CITY OF ALBUQUERQUE

July 16, 2014

**RE: 2117 ST Cyr St
Grading and Drainage Plan
Engineers Stamp Date 5/28/14 (K15-D097)**

**2117 ST CYR GRADING &
DRAINAGE PLAN**

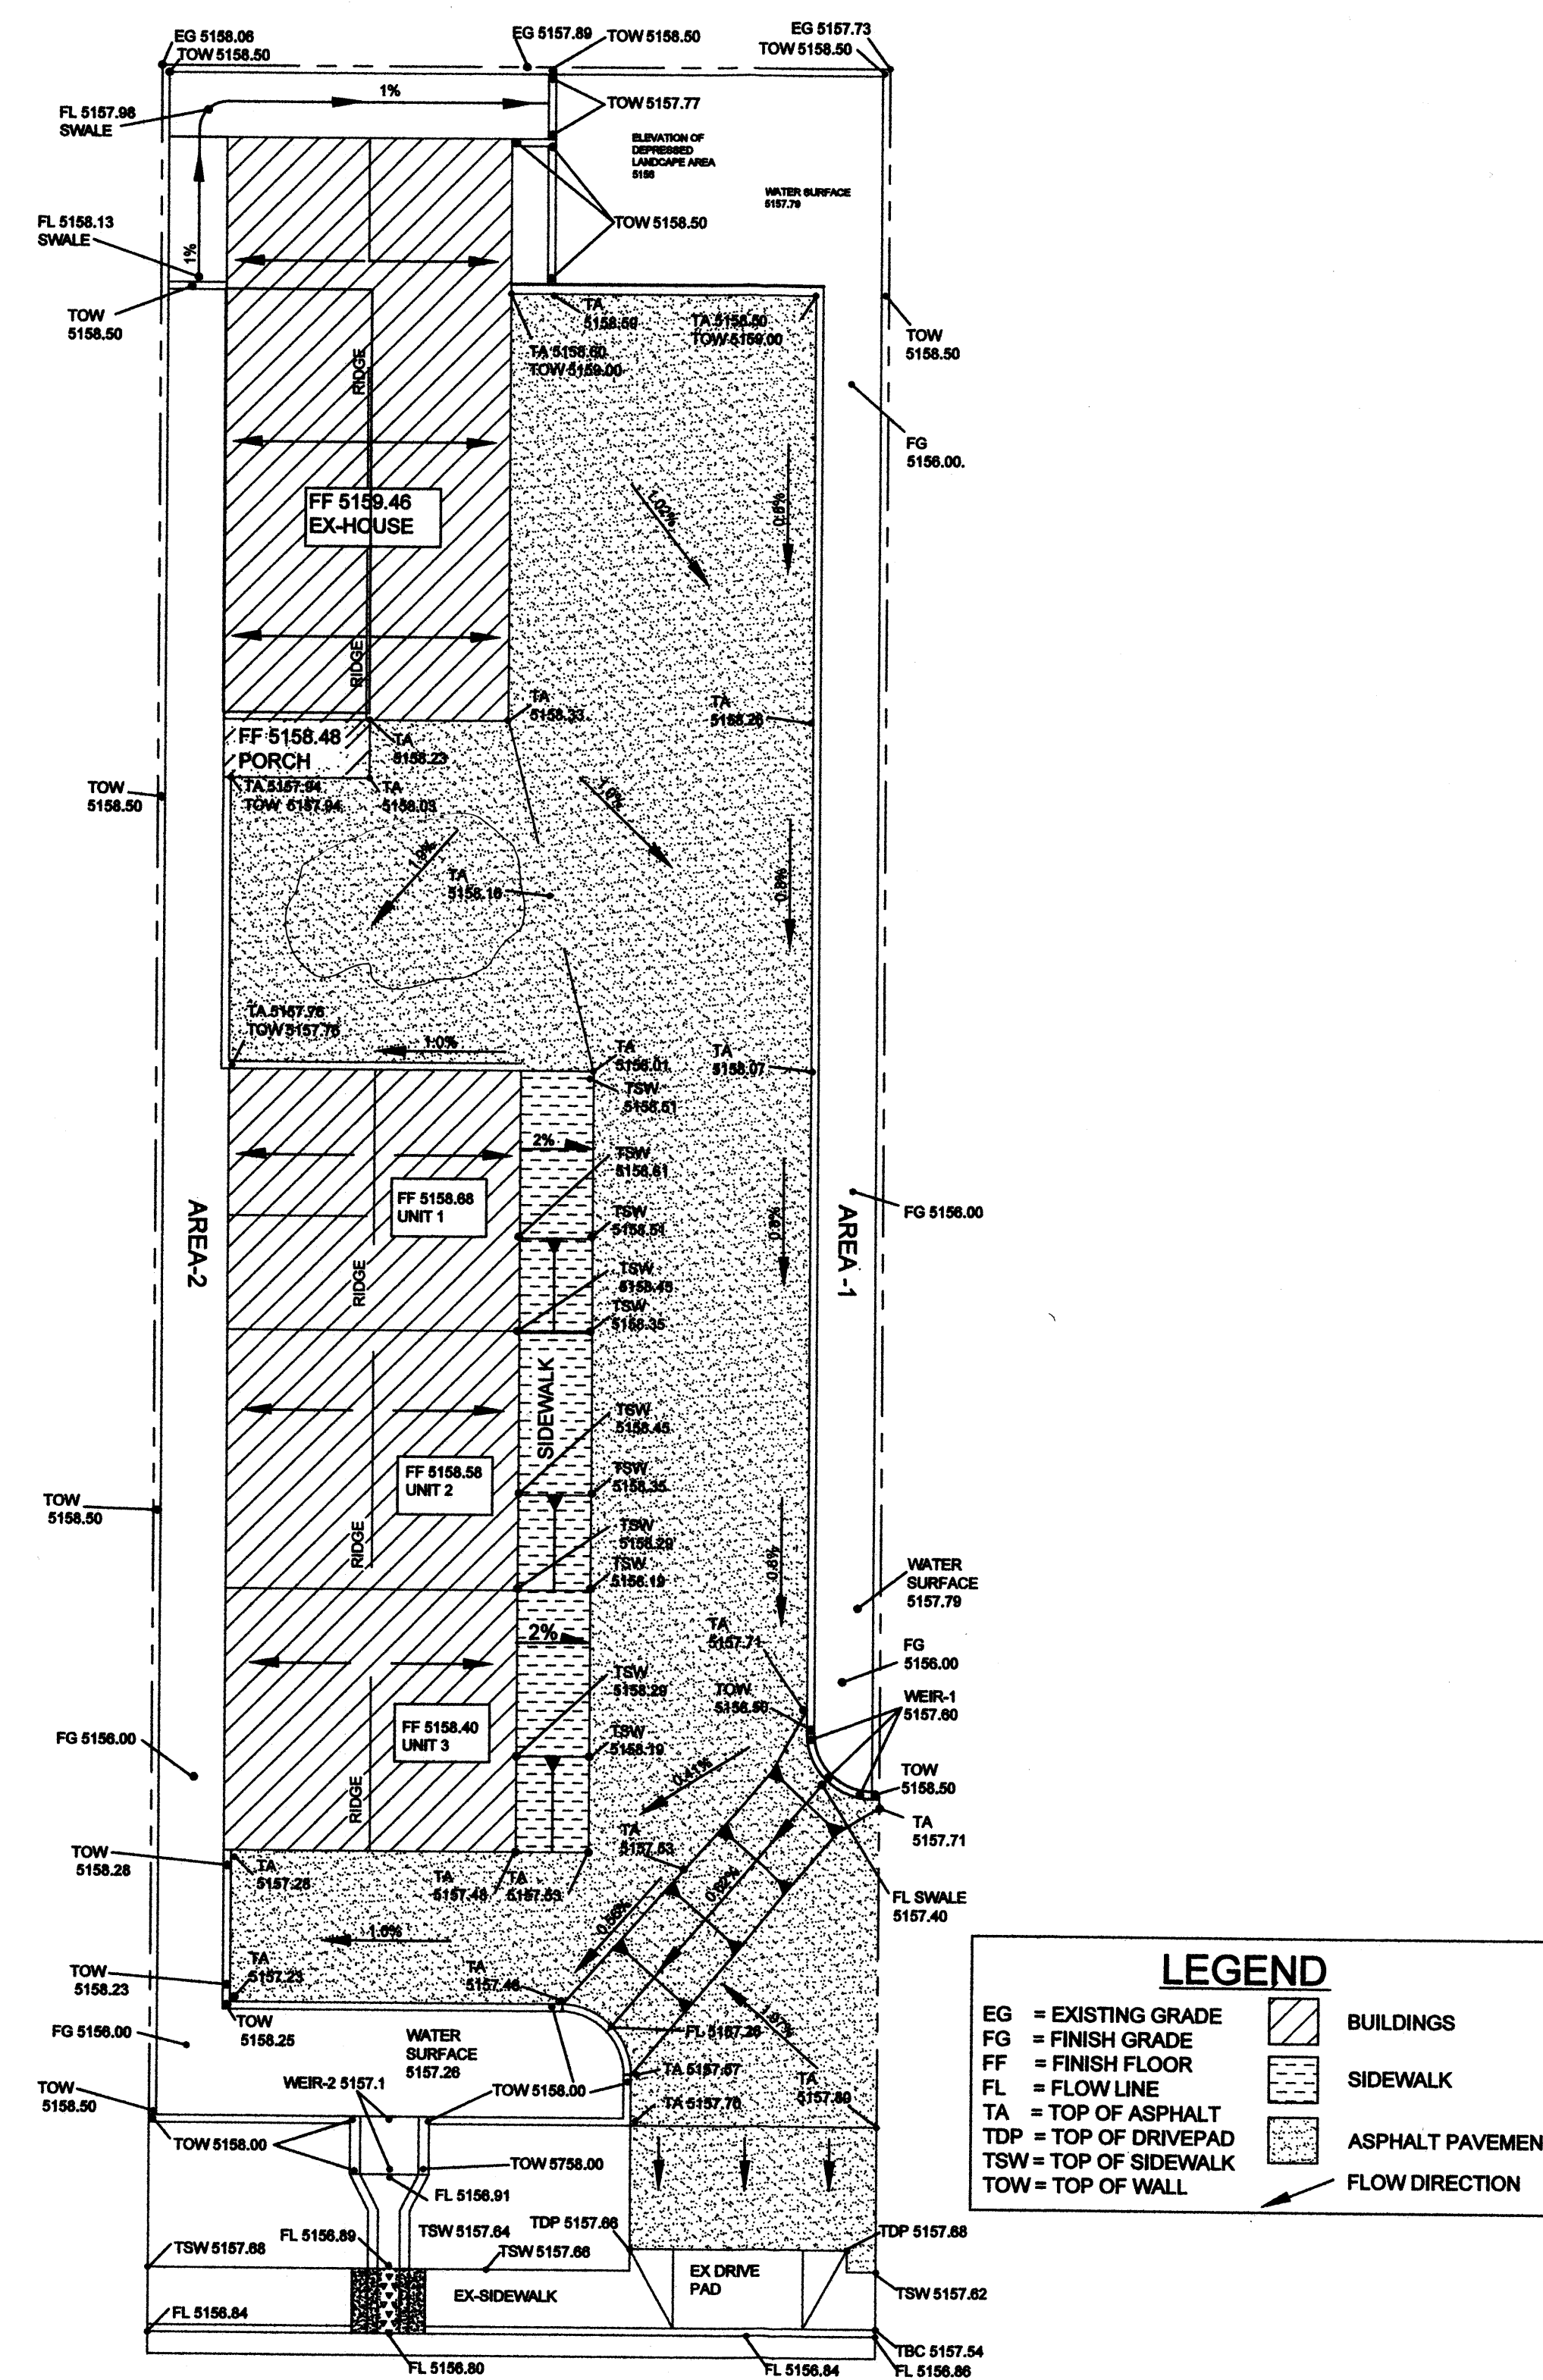
- An SO-19 is required for the placement of the sidewalk culvert. Therefore, the notes for an SO-19 should be placed on the plans. Also provide the hydrology department with two copies of the G&D plan.
